A1 Birtley to Coal House

Applicant's Responses to ExA's Second Written Questions - Appendix 2.10C - Environment Agency confirmation of Flood Model

Technical Model Review Report		
Client	Environment Agency	
Single project or WEM package?	WEM Package	
Package name (if applicable)	2018-19 National Modelling and Forecasting Technical Support Contract	
Project name	Review No. 57 - A1 Birtley to Coal House	
JBA Project Number (or overarching project)	2018s0387	
JBA Sub-Project Number (if applicable)	57	
Review requirements	A) Previous project - hydrology	
	B) Previous project - hydraulic	
	C) New project - hydrology	Yes
	D) New project - hydraulics	Yes
	E) Survey data	
	F) Reporting

B	Review of River Team Viaduct
Date of model	August 2018
Name of reviewer	Jenny Hill
Date of review	03/03/2020
Revision	v3
Applicable standards or guidance	
Nature of study watercourse(s)/constraints	Allerdene Burn
Study objectives	The reporting states: Flood Risk Assessment (FRA) to support the Environmental Impact Assessment (EIA) and DCO Application for the A1 Birtley to Coal House Scheme. Three areas were identified for further modelling: - Hydraulic modelling to the River Team at Junction 67 to assess

Figure 1: URBEXT Map

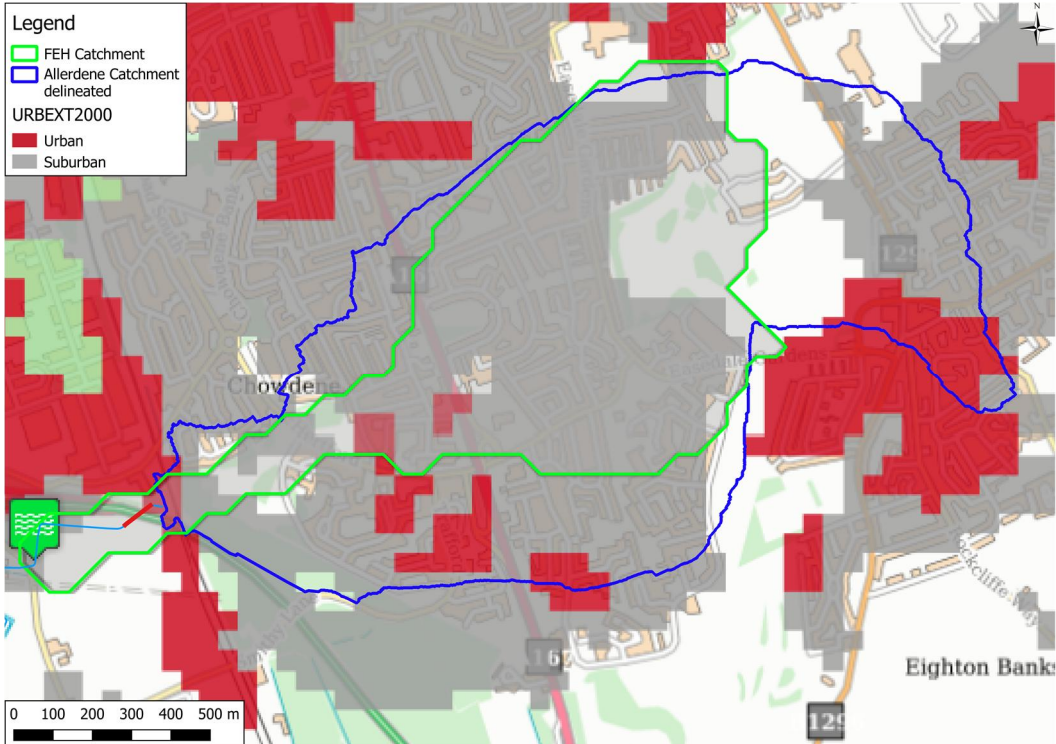
Checks on catchment descriptors	A-6	The catchment area has been correctly checked using LIDAR data, noted that this gives a larger area compared to the "default" FEH catchment.	Major issue	No further reporting given on how the change in catchment area influences other key catchment descriptors. DPLBAR should increase, and there could be significant changes to URBEXT2000 from the change in catchment boundary. Both of these need to be altered, and could have a big effect on calculated flows.	This is addressed within the accompanying technical note	Thank you for updating this. The updated DPLBAR and URBEXT values should give more conservative results in ReFH2. Good method used to update DPLBAR, acknowledging the uncertainty in the AERA*0.548 method for small catchments.	Happy with the given changes.
Data review	Hillfows-UK version	A-7	NRFA V7 is the latest version	Recommendations	Should be used in FEH statistical as an independent check on ReFH2, see below.	This is addressed within the accompanying technical note	See comments below

Figure 2 ReFH2 Growth Curves

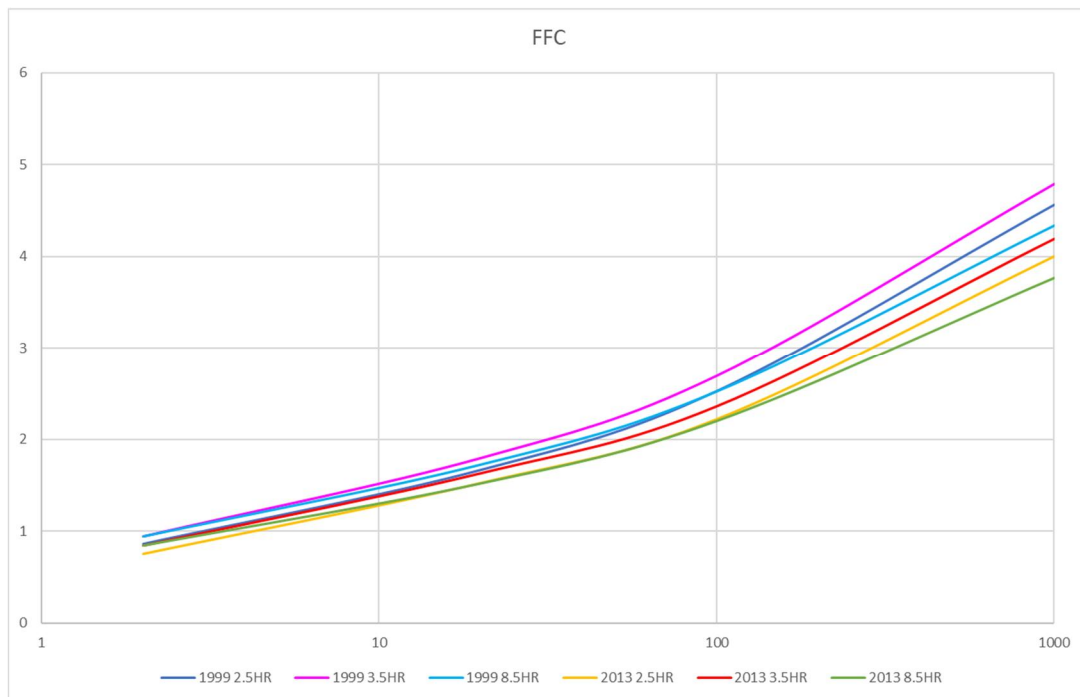
Justification of approach	A-12	A sensible argument is given for using FEH99 rainfalls over FEH13 (although it's hidden in a footnote!), given that the former is reported to give higher rainfall totals in this case. For the purposes of construction options modelling this is a good idea. Some data needs to be presented in the Appendix however to back this up, perhaps a table comparing rainfall totals across multiple storm durations. However using FEH99 rainfall in the ReFH2 model may have an unforeseen drawback. In this situation with FEH99 rainfall, ReFH2 applies the "alpha" factor when calculating runoff (essentially a fudge factor that reduces runoff for increasing return periods - introduced to try to match FEH statistical peaks, but conceptually does not make a lot of sense). So even though FEH99 might give more rainfall, the "alpha" factor may cancel out the effect. This factor is not used with FEH13 rainfall in the model.	Major issue	Add a table comparing FEH99 and FEH13 rainfalls to back up the argument given in Chapter 2 of Appendix A. Run the ReFH2 model for the 100 and 1,000yr events with the FEH13 rainfall also, to test if this gives larger peak flows, due to the "alpha" issue discussed to the left.	This is addressed within the accompanying technical note	Thank you for checking this, Table 2 in the additional note shows using the 1999 rainfall still gives larger peak flows with ReFH2, for various storm durations. Noted that the authors have also checked the ReFH1 method as well for completeness, which is a good idea.	The ReFH1 checks given at the bottom of p.6 / top of p.7 use a different storm duration (1.25hrs) to the ReFH2 results presented further above (3.5hrs). Therefore the comparison of methods in Table 5 of the additional note is not a true like-for-like check. (on permeable catchments ReFH2 is generally preferred to ReFH1 however, so the overall effect on final calculations is likely low).

Figure 3: J66 Flood Depths for the 1 in 100 year (1%) event

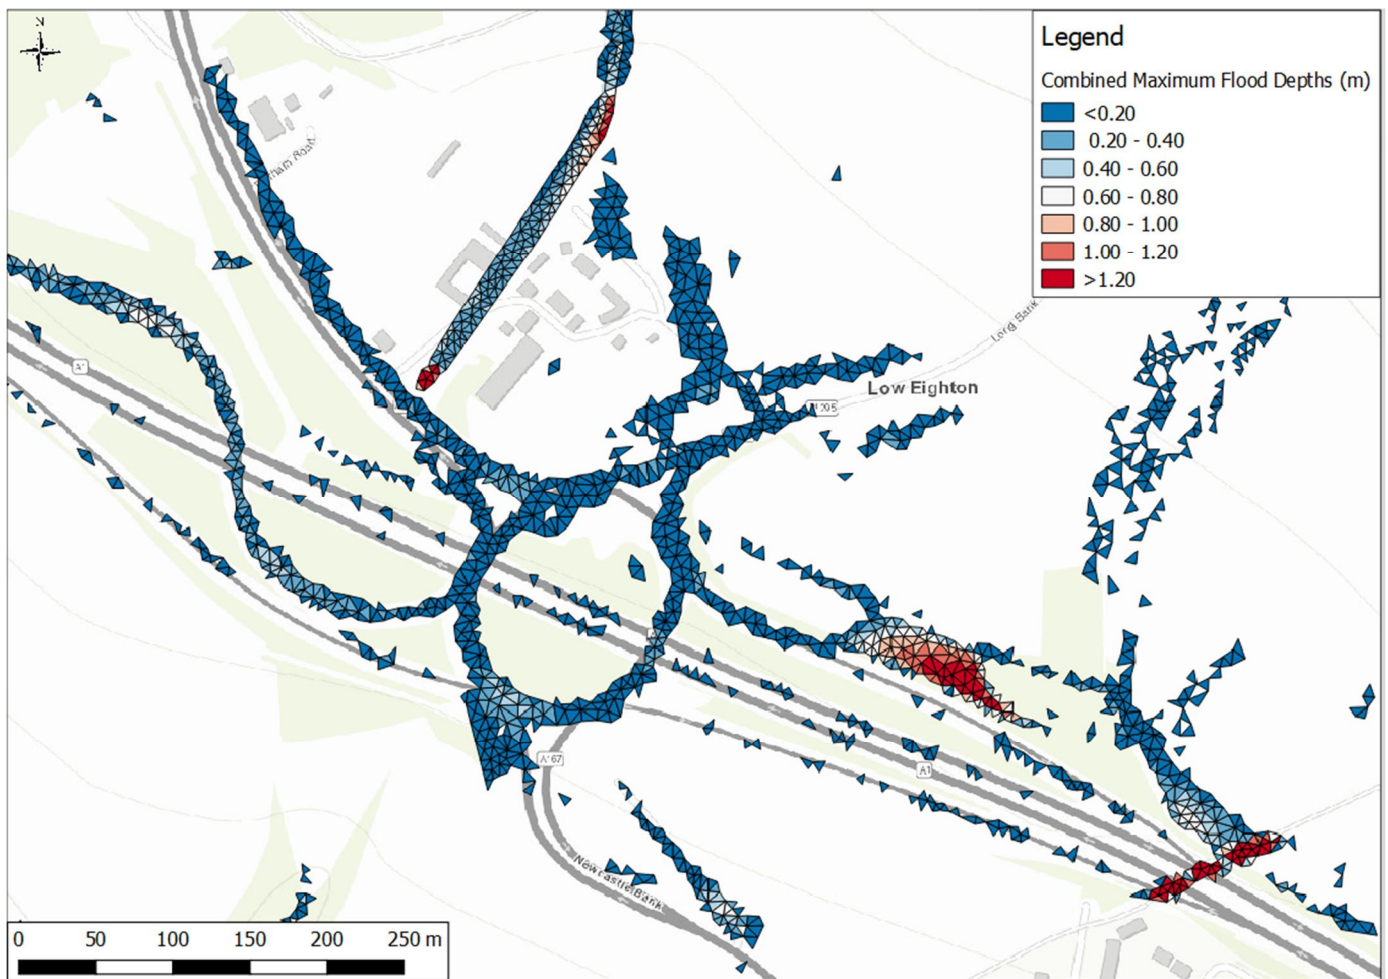
Direct rainfall modelling - range of storm durations tested	A-32	There is no information given on the range of storm durations used in this direct rainfall modelling in the report. The EA national-scale pluvial mapping runs separate models for storm durations of 1hr, 3hrs and 6hrs, then merges the modelled maximum depths in a final grid. This allows for runoff rates on regions with different topography to influence the results. A similar method needs to be adopted for this more detailed assessment.	Major issue	Run the direct rainfall model for a range of storm durations, then merge the results taking the maximum from each individual model grid.	The model has been tested against the critical duration for the catchment, the national modelling was undertaken at a significantly larger scale and therefore wasn't looking at an individual catchment and couldn't be certain on the impacts/critical duration in scheme specific terms. In this instance, we are assessing the potential flow routes and flood depths on a slip road which will need to be managed, it is not considered necessary to undertake further analysis, as no changes to surfaces or flow routes or buildings are proposed	Noted. Information given in the additional note seems to have carried out this procedure anyway, noting that the 1-hr storm gives the most conservative result.	No further action required

Figure 4: Improvements to channel and left bank flows for the Kingsway Viaduct river reach (TEAM_5156.1) because of lowering the bank modular limits to 0.6 (option model)

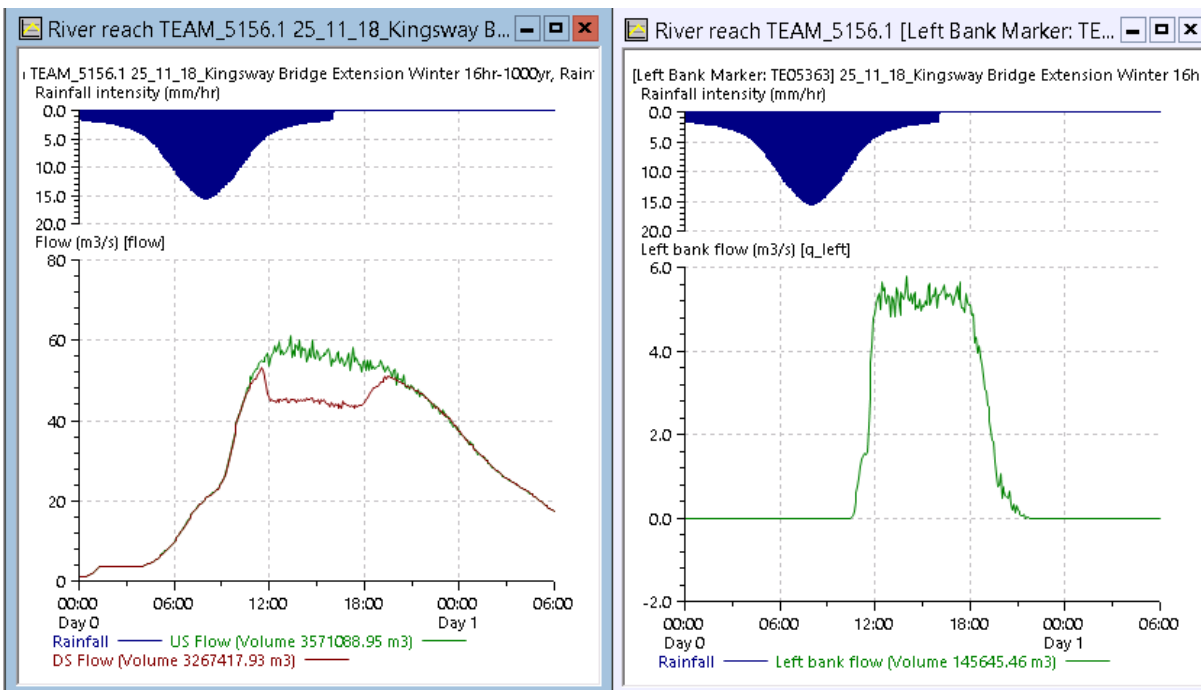
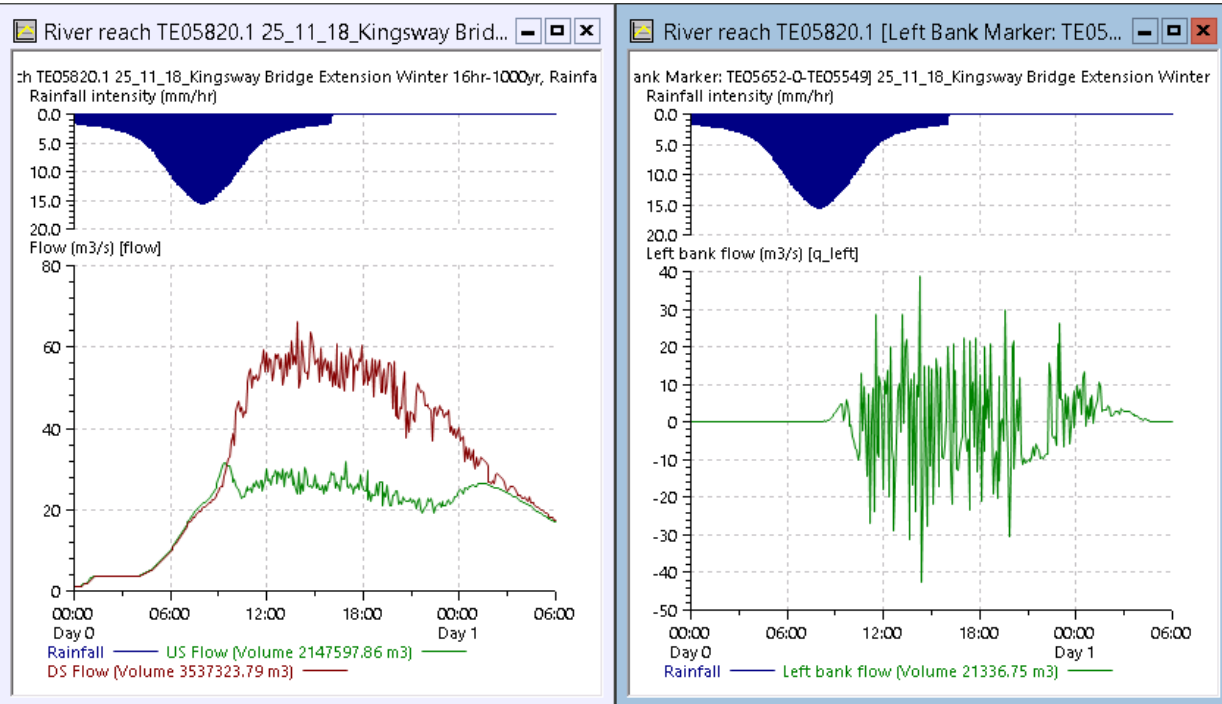
B-143	There is some significant oscillations in the out of bank flows in the area of interest during the 0.1% AEP event (figure 3)	Major issue	Make updates to conveyance and bank lines to improve stability. If appropriate, lower bank co-efficient	See response to B-29	The consultant has documented attempts to improve stability as suitably justified the approach and documented the limitations.	No further action required.	
Sensitivity testing	- Suitability of sensitivity testing undertaken - Results & interpretation of sensitivity testing	B-144	Sensitivity tests not provided for review	Minor issue	Run sensitivity tests	See response to B-137	The consultant has documented the model's sensitivity to channel roughness. This did not suggest any amendments to the base model where required.	No further action required.
Calibration / performance		B-145	No model performance testing was provided for review.	Minor issue	Use the model report to provide commentary on the sensibility of predicted flooding.	This is addressed within the accompanying technical note	The consultatn has provided justification for not completing model proving.	No further action required.
